**KIRKLEES METROPOLITAN COUNCIL
INVESTMENT & REGENERATION SERVICE**

DELEGATED DECISION TO DETERMINE PLANNING APPLICATIONS

Reference No:	2024/60/90681/W
Site Address:	adj, 1, Newsome Avenue, Newsome, Huddersfield, HD4 6JW
Description:	Outline planning application for erection of detached dwelling
Recommending Officer:	Lucy Taylor

DECISION – REFUSED

Suggested Site Plan 1:200

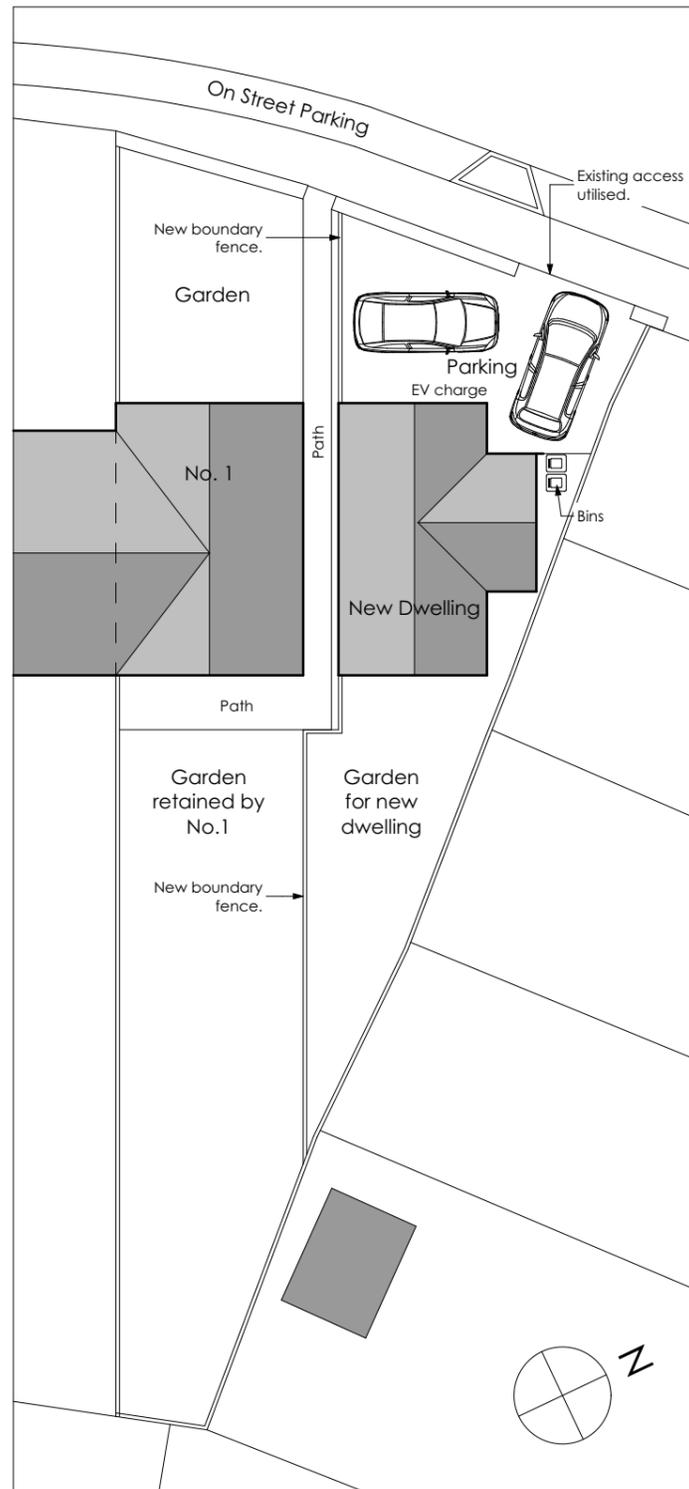
The proposal would have the subdivision of the curtilage of No.1 Newsome Avenue and would result in the new dwelling being viewed as being within a cramped and obscurely shaped plot, with a layout which contrasts with the existing arrangement of established residential development within the street scene and surrounding area, whereby the established vernacular is terrace properties sited within a similarity sized / shaped plot, which is long and relatively narrow.

Whilst the indicative layout plan suggests that the property's placement and building line would align with the principal elevation of No. 1 Newsome Avenue, the proposed dwelling would have a projecting gable to the side elevation, creating a prominent protrusion and feature which is out of keeping with the architectural form of properties located along Newsome Avenue.

Given the obscurely shaped arrangement of the site and its cramped appearance, on-site parking would be limited to the frontage, this would see parking to the entire frontage of the proposed dwelling dominated by vehicle clutter and hard surfacing, contrary to Principle 12 of the Housebuilders Design Guide SPD. The effect of this would be worsened by the loss of the existing front garden amenity space to No. 1 Newsome Avenue, whereby compensatory parking is shown to the front elevation of this property on the submitted 'suggested site plan'. As a result the entire frontage of this part of the street would be parking dominated, and the loss of soft landscaping would detract from the character and appearance of the host property and wider street scene.

The indicative 'suggested site plan' shows the relationship of the dwelling to site boundaries and shows the dwelling to have a footprint of approximately ~37.8sqm. It would have its primary elevation set back approximately ~4 metres minimum from the pavement. The new dwelling would meet the newly created shared boundary with No. 1 Newsome Avenue, retaining a separation distance of approximately ~1 metre from the adjacent side elevation of this dwelling. The extent of the new dwelling would nearly meet the shared boundary with No. 10 St Johns Avenue, and it would be located in close proximity to the shared boundaries with the other terrace properties within the same row along St Johns Avenue.

Given the constrained and obscurely shaped nature of the site, it is not considered that the proposal could be amended so that it strictly complies with the expected 2 metres distance as set out within Principle 6 of the Housebuilders Design Guide SPD. Therefore, it is considered that a new

The siting of the proposed dwelling, based on its position in the submitted 'suggested site plan' would be separated from the rear elevation of No.'s 10a and 10 by a minimum distance of approximately 16 metres.

The scale and massing of a new two-storey dwelling is concluded to have an oppressive impact, leading to an unacceptable loss of outlook and overbearing effect on the neighbouring properties of No. 10a and 10 St Johns Avenue.

In terms of external amenity space, the submitted 'suggested site plan' shows a restricted rear garden to serve the dwellinghouse, with a total footprint of

approximately 40sqm. When compared to the footprint of neighbouring gardens, this is relatively small. In addition, the rear garden is shown to be of an obscure shape with an angled rear boundary, which would work to further restrict the extent of useable outdoor amenity space.

Given the limited extent of outdoor amenity space shown as a result of the layout of the proposed residential development, it is not considered that it would be adequately usable for future occupiers. Therefore, the proposal would be considered contrary to policy LP24b of the Kirklees Local Plan, Principle 17 of the Housebuilders Design Guide SPD and Chapter 12 of the NPPF.
